City of Portland, Maine - Building or Use Permit Application

Permit No: 02-0154	Issue Date: MAR 4 2002	CBL: 076 A013001
-----------------------	---------------------------	---------------------

Location of Construction: 26 Frederic St	Owner Name: Ayor-akol Pio Okuc	Owner Address: Po Box 8203 CITY OF PORTLAND 56-5640
Business Name: n/a	Contractor Name: Dupuis, Raymond	Contractor Address: Box 8119 Portland Phone: 207-84901
Lessee/Buyer's Name: n/a	Phone: n/a	Permit Type: Additions - Multi Family Zone: R-6

Proposed Project Description: Build 4' x 20' deck and 7" x 11" stairs.	FIRE DEPT: <input checked="" type="checkbox"/> Approved <input type="checkbox"/> Denied	INSPECTION: Use Group: R-2 Type: SB BOCA 1999
	Signature: <i>[Signature]</i>	Signature: <i>[Signature]</i>

pg 3 of 4

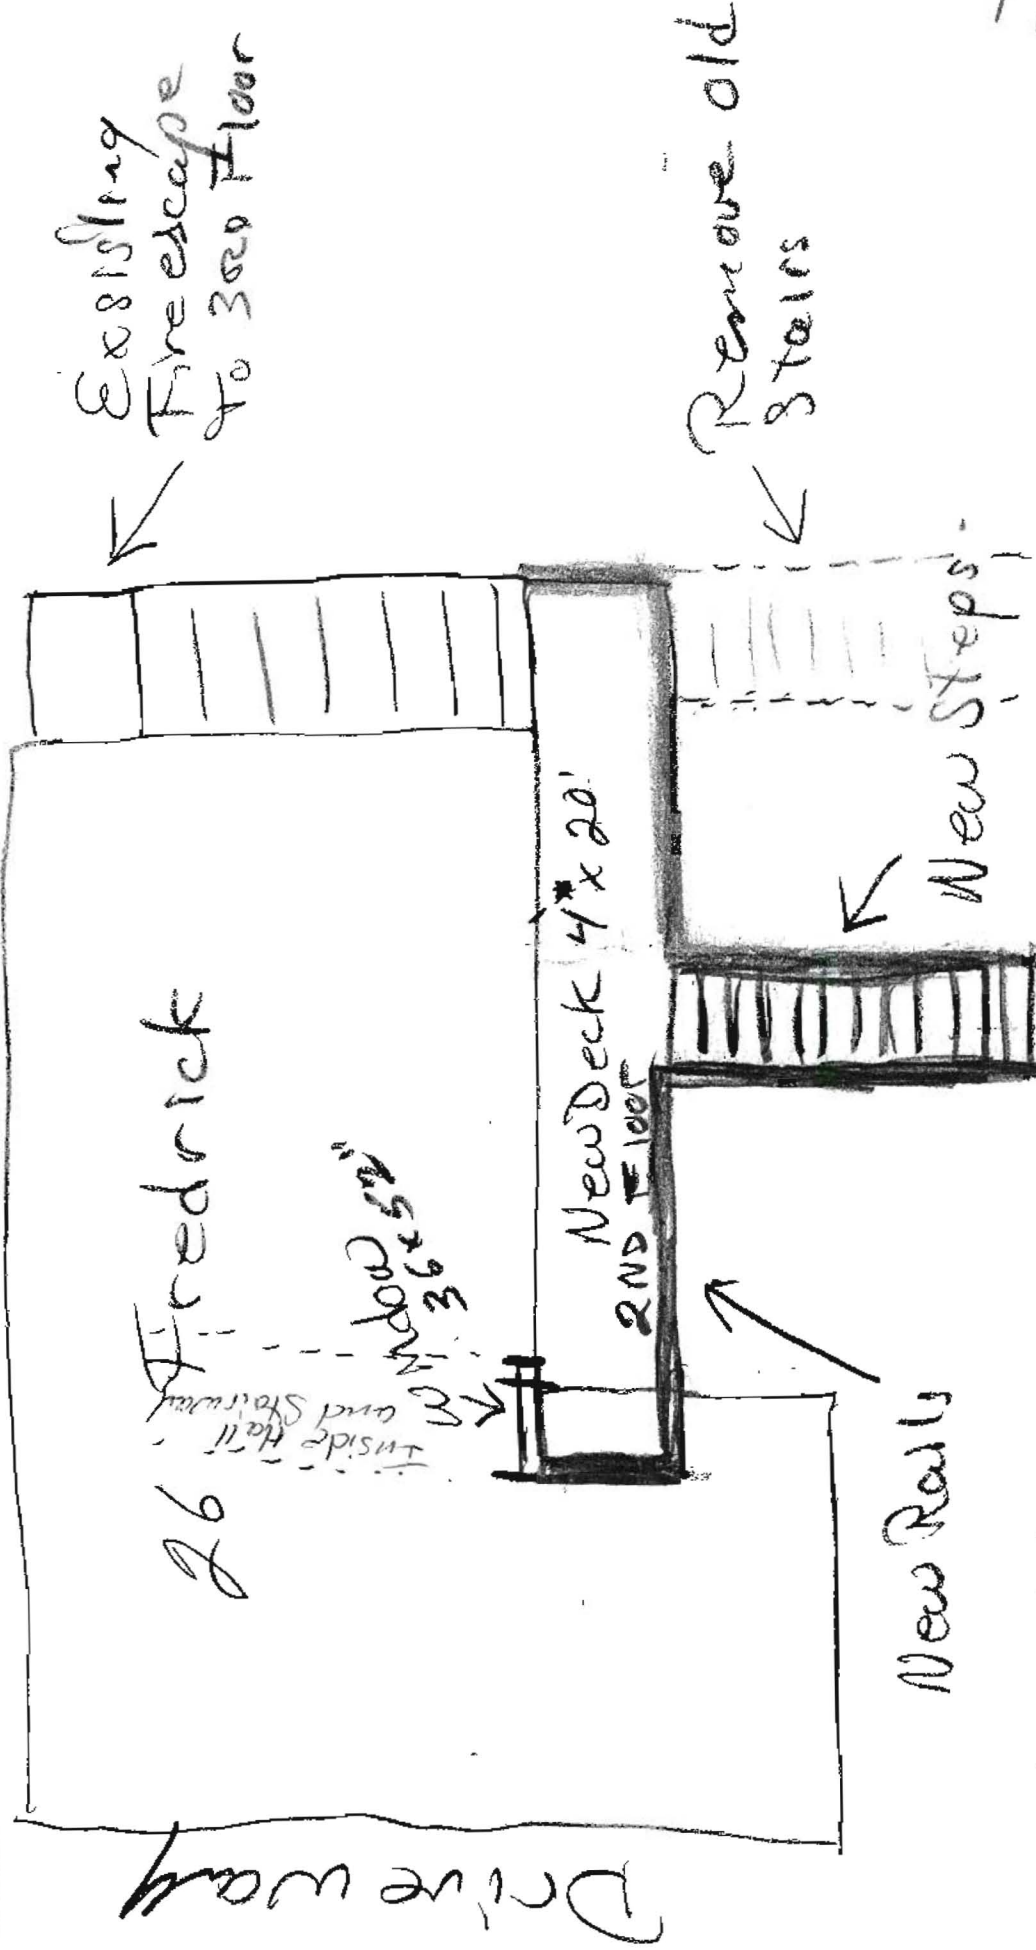
- ① Girder? - 2 - 2"x8" - 6'-0" span - OK
- ② Posts + sauna tubes? - 4"x4" ~~posts~~ + bolted to house
- ③ Guardrail system w/handrail - 42" high w/graspable handrail
- ④ Riser boards? - will have riser boards.

Went over all of the above w/ Raymond Dupriis - OK
to issue. 4M.

Plot 4

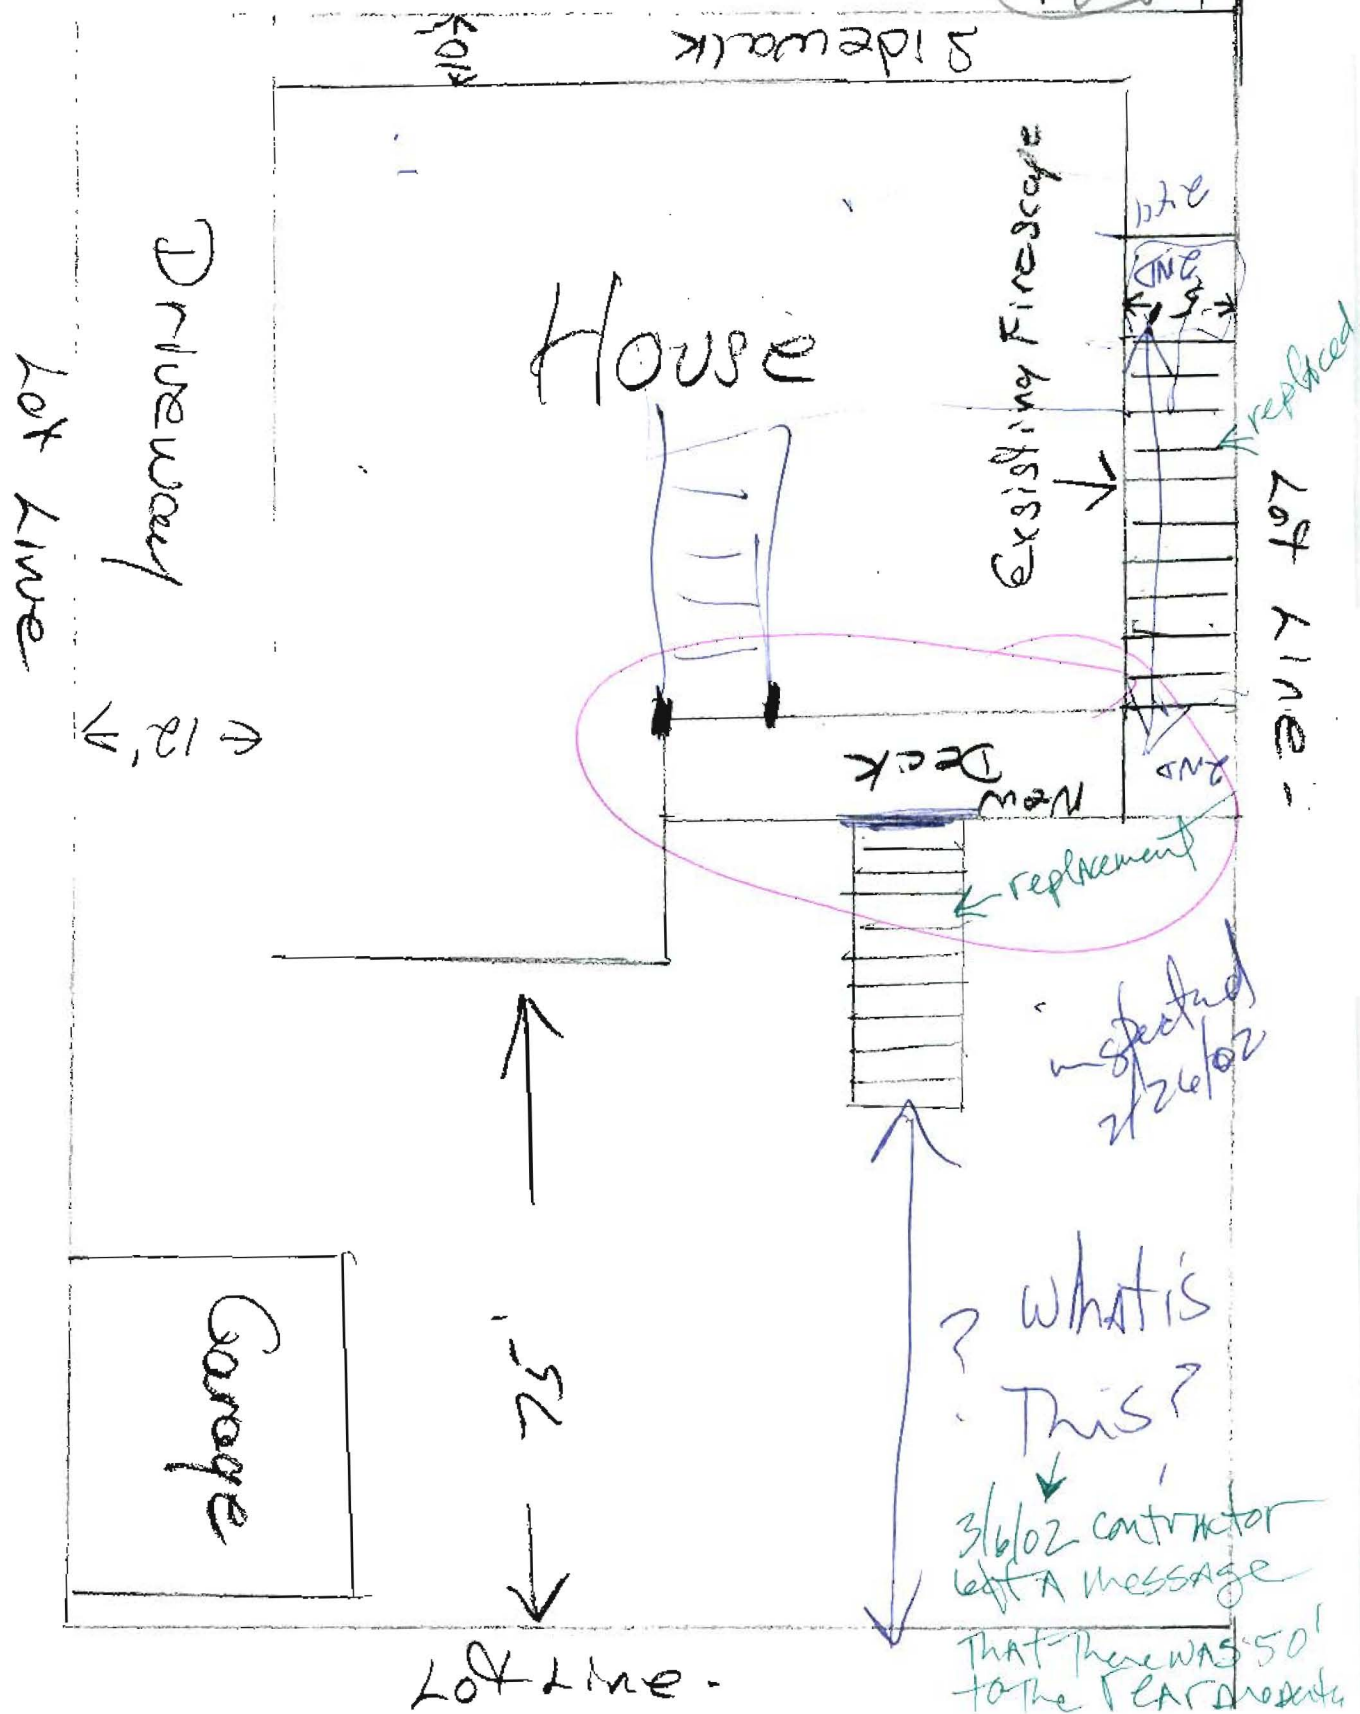
Comments: 26 Frederic St
2/26/02 requested setback from edge of stairs to rear property line. - visited property to view existing fire escape
3/6/02 - 50' plus to rear property line from edge of stairs.
